From: Martyn White
Sent: 17 January 2022 17:41
To: Planning.Responses
Subject: BR/247/21/PL

BR/247/21/PL

Ancient Mariner Hotel 59 West Street Bognor Regis PO21 1XB

Change of use from single dwelling (C3) to 6 No self-contained flats (C3), a 10-bedroom co-living housing unit (Sui Generis) & insertion of 3 No new front windows. This application affects the character & appearance of The Steyne, Bognor Conservation Area.

client	SPP
project	Ancient Mariner 59 West Street Bognor Regis PO21 1XB
project ref.	2553 Drawing No. 06
drawing title	Proposed elevations
drawn by	L.F.
date	June 21 scale 1:100@ A1
	www.bpmnet.co.uk info@bpmnet.co.uk

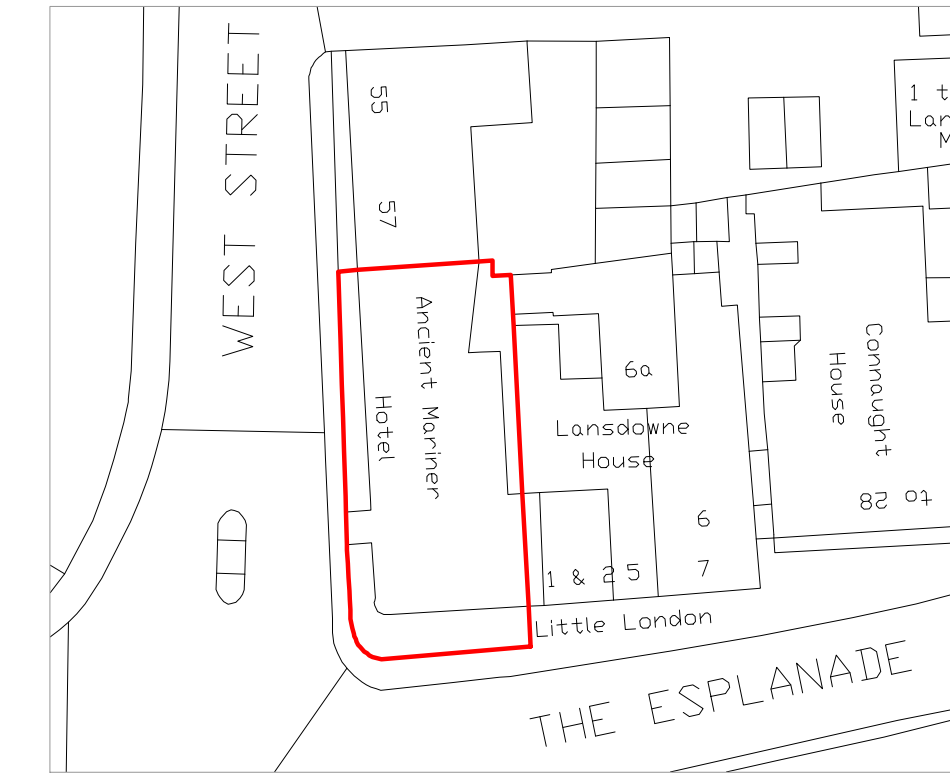
Three new windows are proposed for the southern elevation. At present there is a simple appearance to this elevation and there is a risk that any further windows will alter this and the 'flow of the elevation'. However, I am also of the opinion that the additional windows could not cause harm to the elevation, if they are carried out to a high quality. I note (in the Design, Access and Heritage Statement) that the intention is for the windows to be timber sliding sash windows which would be designed and detailed to match the existing three windows to the western side of the southern elevation. This is also a positive element of the proposal, which means that on balance, it is acceptable. I would hope that this approach could be repeated on other buildings in the local area. Any new windows should be recessed within the openings to the same depth as the existing ones so as to ensure that they do not detract from the attractive elevation. However, whilst positive, I would want to further details to be provide regarding them in order to ensure that they are fully appropriate fo the building and area. This additional information could be achieved by way of condition if the application is approved. Details would have to include precise details of the new windows including their materials, finishes, details of the frame and glazing bars, operating mechanisms and depths of reveals. Information should be provided in the form of drawings to an appropriate scale.
